From: Liz Annalls [REDACTED]
Sent: 15 December 2020 10:40
To: Planning.Responses <Planning.Responses@arun.gov.uk>
Subject: RE: Planning Consultation on: BE/148/20/OUT

App No: BE/148/20/OUT
Address: Nursery Fields Land to the North of Chalcraft Lane West Bersted PO21 5TS
Description of Works: Outline application with some matters reserved to provide up to 225 residential units with associated infrastructure, open space and vehicular and pedestrian access. This application affects a Public Right of Way.

PLAN ECO3
Bat Survey Plan

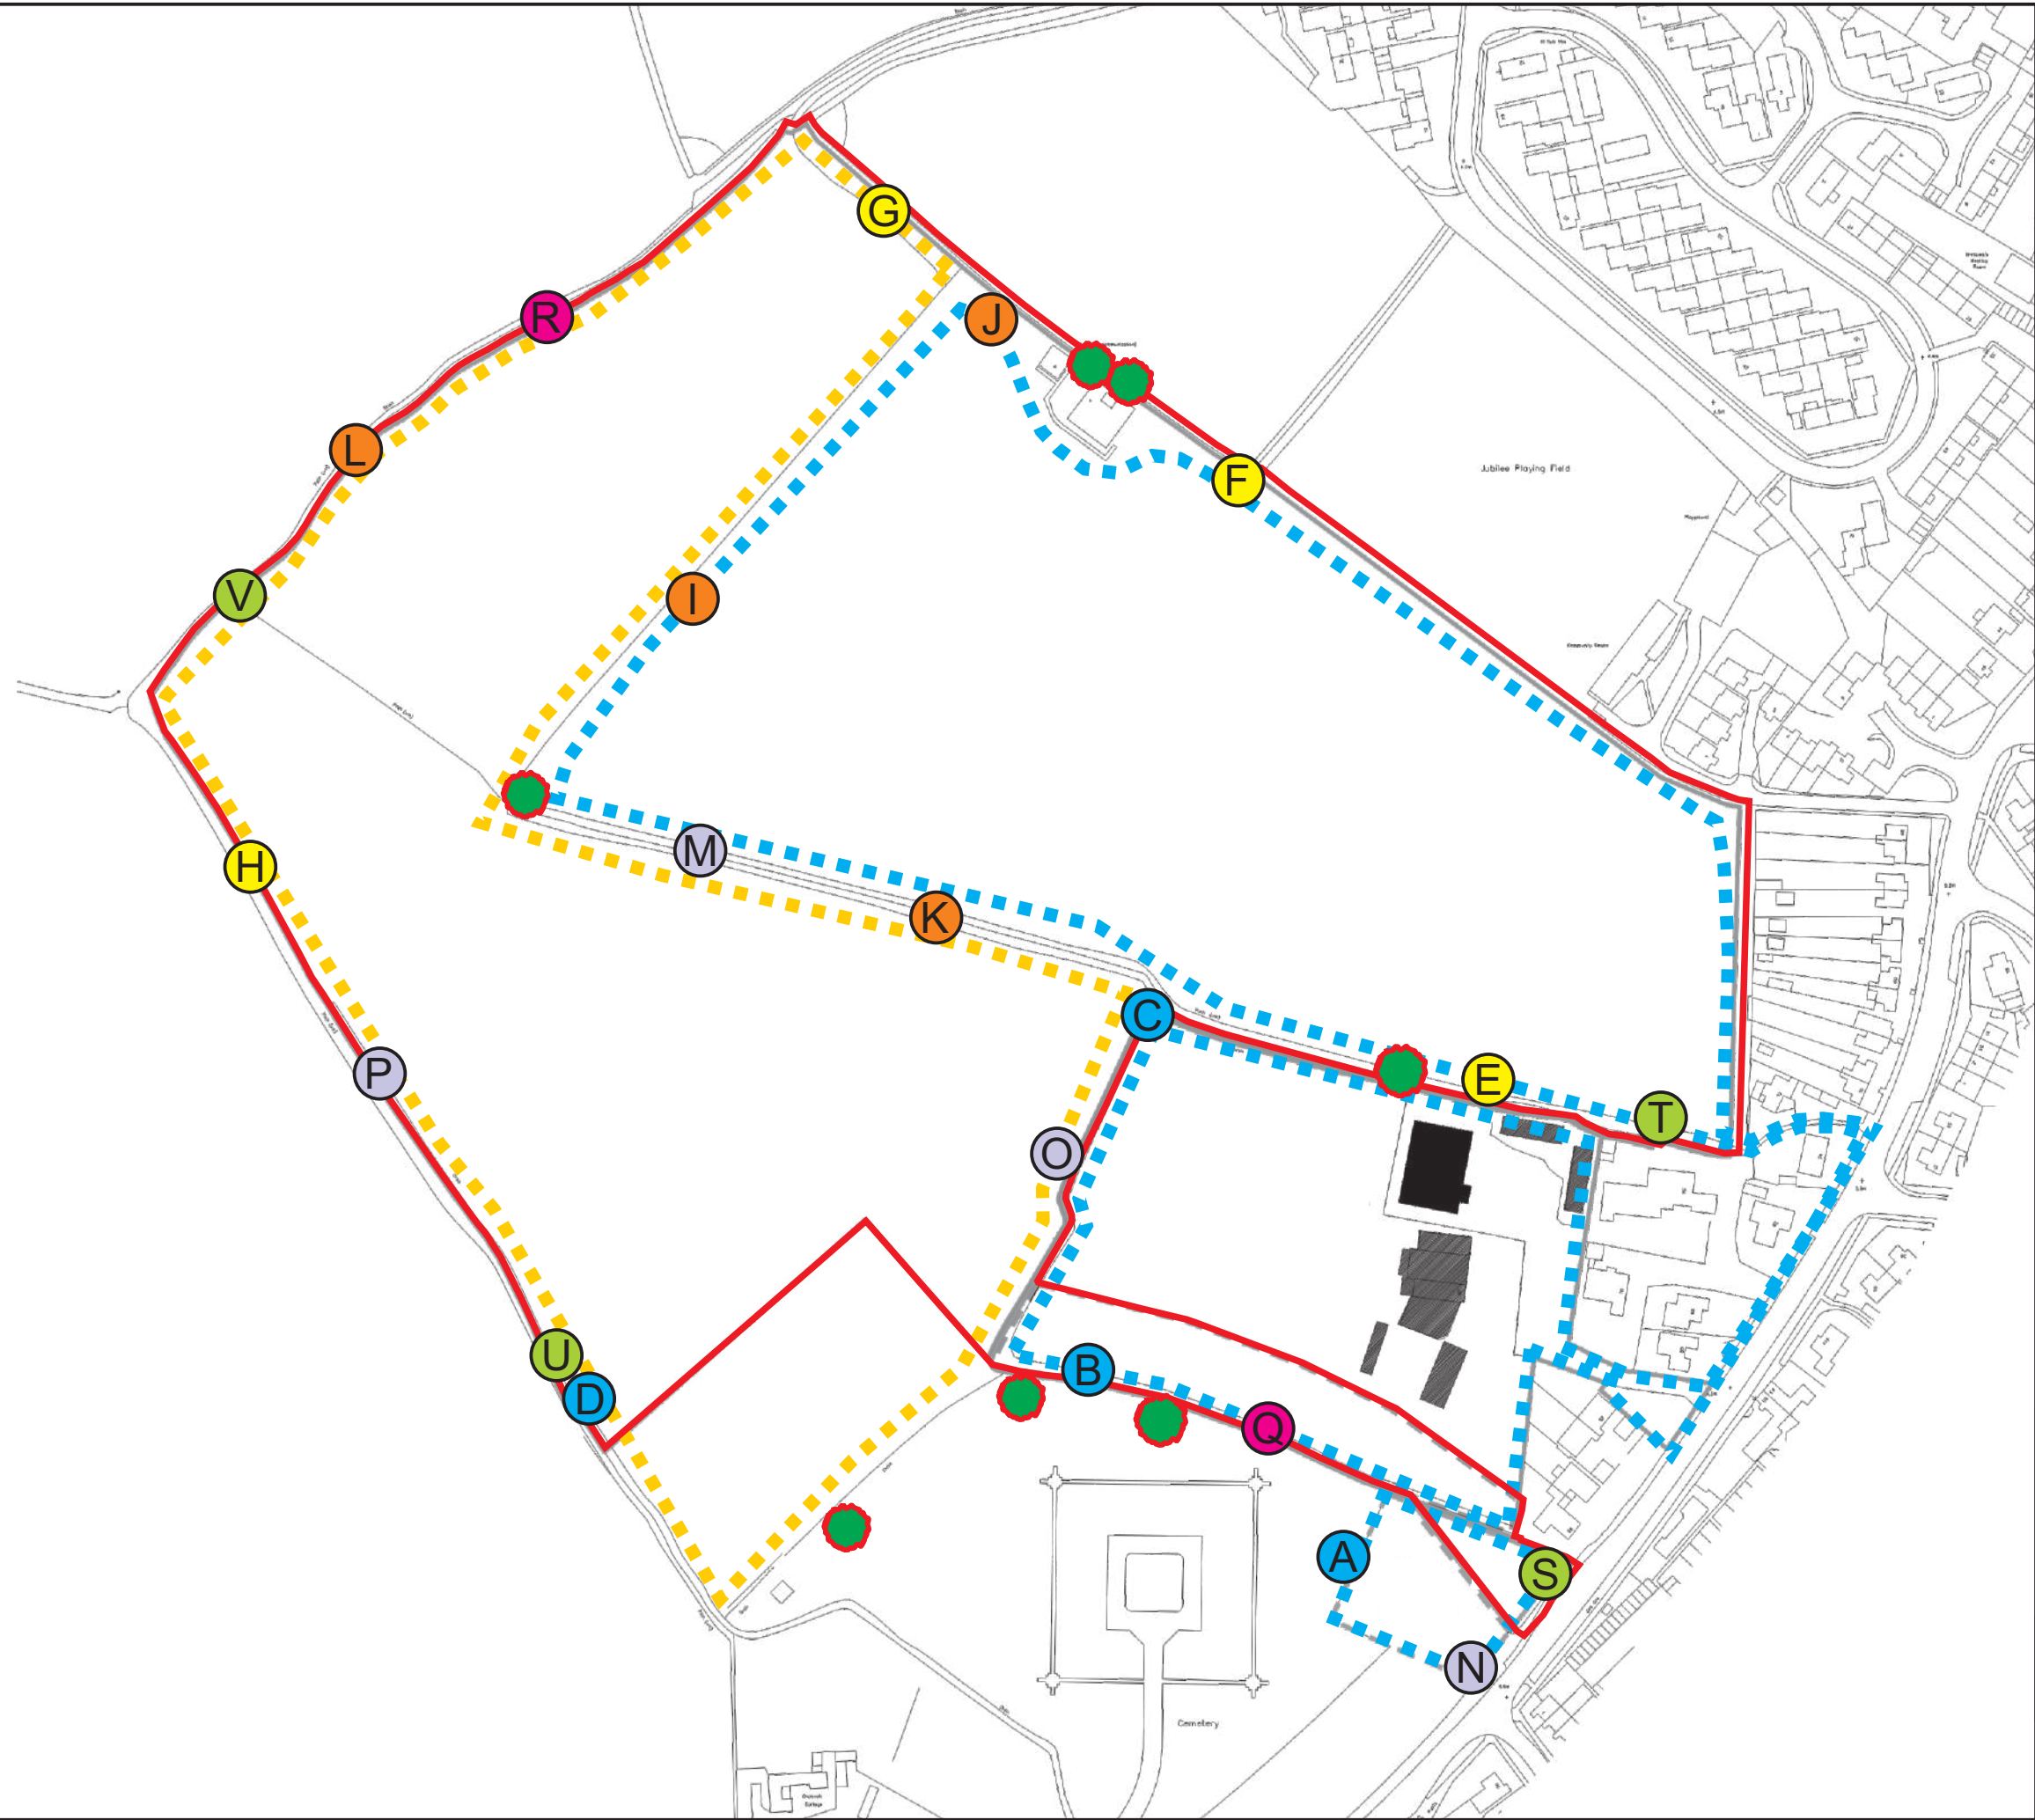
As detailed within the Ecological Assessment (Oct 2020) there are 5 mature trees onsite which support bat roosting potential. These trees must be retained and protected from disturbance. If this not possible then further bat surveys will be required on these trees.

The lighting scheme for the site will need to take into consideration the presence of bats in the local area and the scheme should minimise potential impacts to any bats using the trees, hedgerows and buildings through the provision of dark habitat orientated north-south direction and avoiding unnecessary artificial light spill through the use of directional light sources and shielding. We require that further details of the lighting scheme and dark corridors are provided as part of this application.
